**Heckmondwike Bus Station** *(part of the Transforming Cities Fund programme)*

**APPENDIX A - VER 1 Kirklees Road Safety Audit Procedures – SPD – Internal Audits**

## **ROAD SAFETY AUDIT PROBLEMS**

20233 - SGP - HEK-ZZ-DR-A- 021301

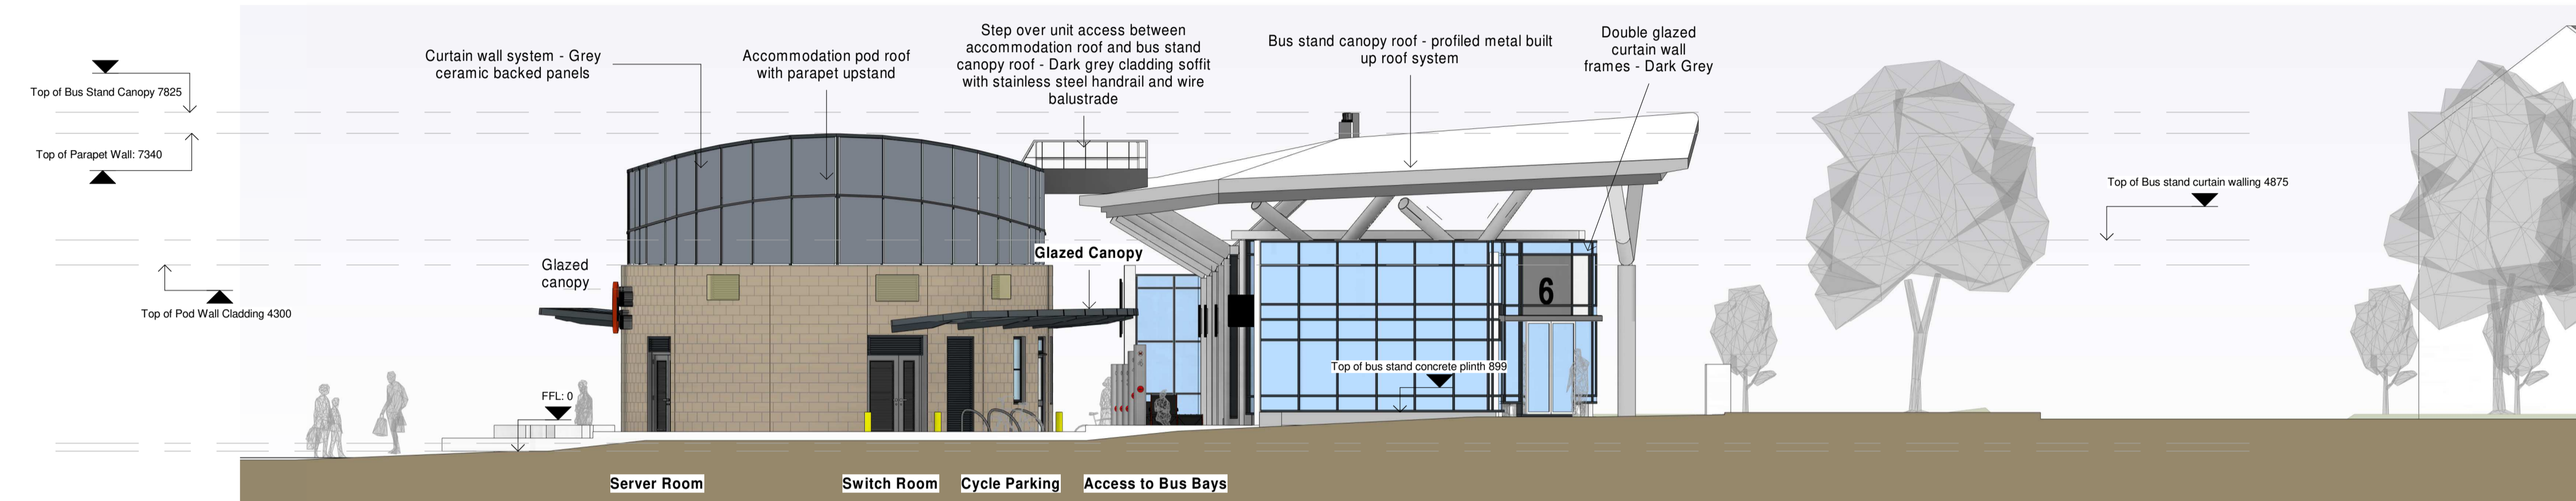
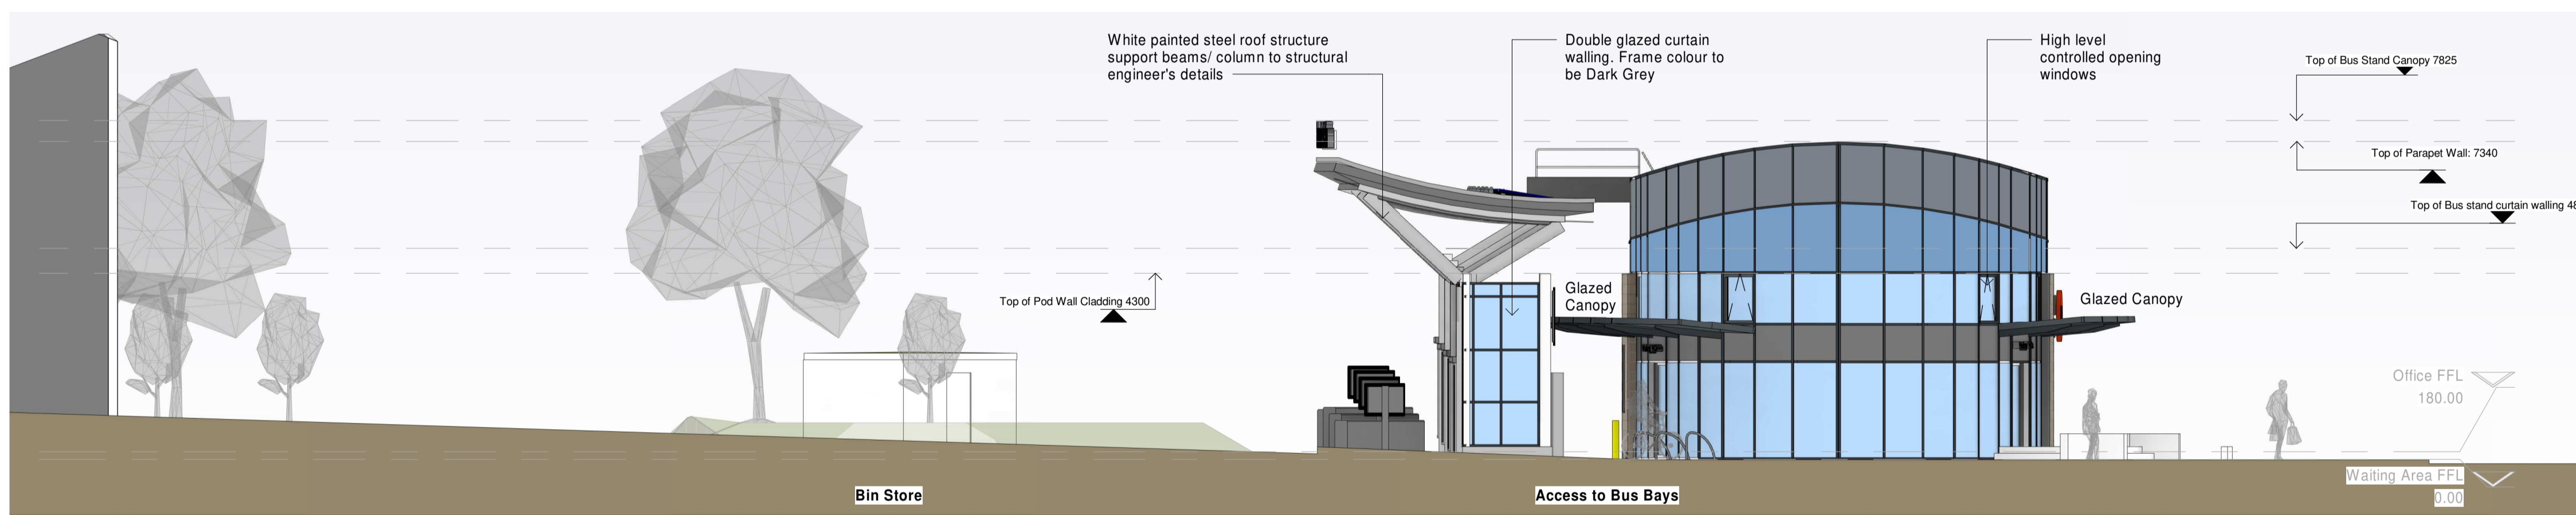
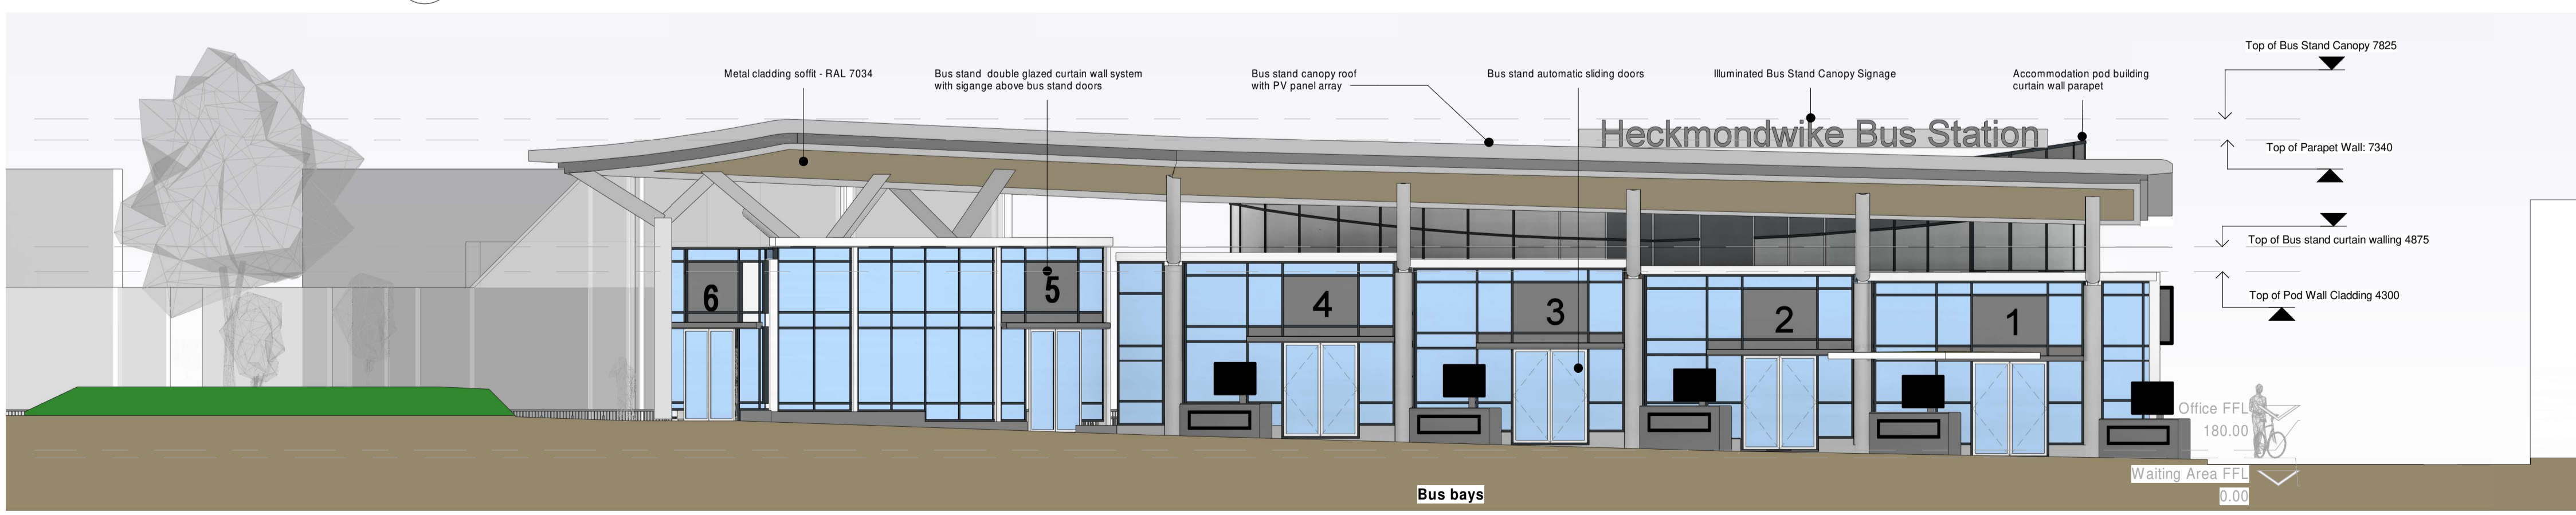
The scheme proposes an unorthodox and potentially hazardous layout and manoeuvring system for buses (it is assumed) to maximise capacity. The layout would necessitate buses reversing from the front of the bays and turning, before turning again and leaving the site forwards. These manoeuvres would be difficult to execute safely, and drivers would need to see clearly in all directions across the rear/sides of their vehicles. Looking at the vehicle swept path movements provided for audit, it seems highly likely that this system could only operate safely if only one bus were permitted to execute an exit manoeuvre at any given time, and only then if no other buses were entering the site at the same time.

Whilst it is acknowledged that cameras would be provided, it is not clear how far these could mitigate safety concerns. The VDUs proposed at the front of the bays may only be clearly visible to bus drivers when they commence reversing (depending upon size and drivers' sight), and without restrictions on conflicting movements in place, they would only be of limited benefit. The further back buses reversed, the less visible the screens would be, and the most hazardous conflicts would occur towards the rear of the parallel bays where other buses entered the site.

The revised Proposed Site Plan (20233-SGP-HEK-ZZ-DR-A-021001 P8) shows a reversing camera system will be installed at each Drive-In-Reverse-Out (DIRO) stand so drivers can view what's behind them as they reverse. This comprises a reversing camera screen at the front of each stand and reversing cameras located at the rear of the layover bay.

**Figure 4-1 – Proposed Site Plan**

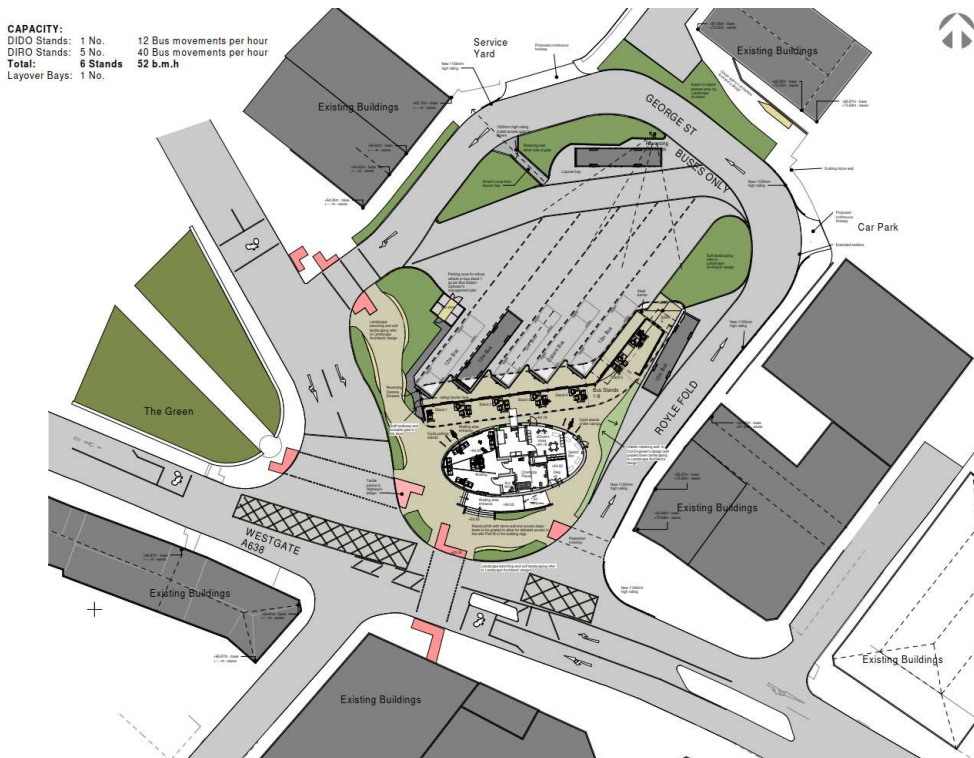
Currently pedestrians can cross in relative safety between the footway bordering the north-eastern side of South George Street and the footway bordering its south-western side (i.e., to/from the periphery of the bus station), only having to consider traffic moving in one direction around the one-way system. However, under the proposed layout there would be no footway routes around the northern periphery of the station. To mitigate for this, the proposals include guardrail along much of the outer verge of South George Street to block pedestrian crossing desire lines to and from the bus station. However, due to the retention of four existing parking bays there would be gaps in the rails where pedestrians could freely walk through. The proposed carriageway area of the bus station adjoining the parking bays would be extremely hazardous for pedestrians to negotiate, with buses manoeuvring in multiple directions, including reversing. There would be a high risk of pedestrians being injured if they attempted to walk through this area.

It also seems highly likely that significant numbers of pedestrian will want to execute these movements. Most passengers using the bus station living in areas to the north of the site would be likely to walk via George Street. Also, pedestrians heading to and from some retail destinations south of the site may also choose to take a direct path through the centre of the bus station.

The parking bays should be removed, and the guardrail made continuous across the entire north-eastern section of South George Street.

The revised Proposed Site Plan (20233-SGP-HEK-ZZ-DR-A-021001 P8) shows that the four parking bays to the north of the site have been removed and replaced with a raised planted area, as part of the landscape strategy for the site. A continuous guardrail (1100mm high) is now proposed between the dentist car park and eastern edge of the proposed raised planted area. A continuous guardrail is also proposed along the eastern side of the site on Royle Fold between the dentist car park and the pedestrian crossing at the entrance to Royle Fold, with the footway widened to retain the effective width.

The proposed raised planted area to the north extends west towards the footway on South George Street and there is a separate landscaped area located along the western side of the site between the crossing point for the drivers route to the layover bay and the signal controlled crossing point. There is also an additional landscaped island between South George Street and the bus apron that will discourage pedestrian movements. The drivers route to the layover bay has a 1200mm high railing coded access gate, along with a retaining wall either side of the gate to discourage pedestrian movements.

In combination these proposals will direct pedestrian movements to the perimeter of the site and prevent pedestrians taking a direct path through the centre of the bus station.
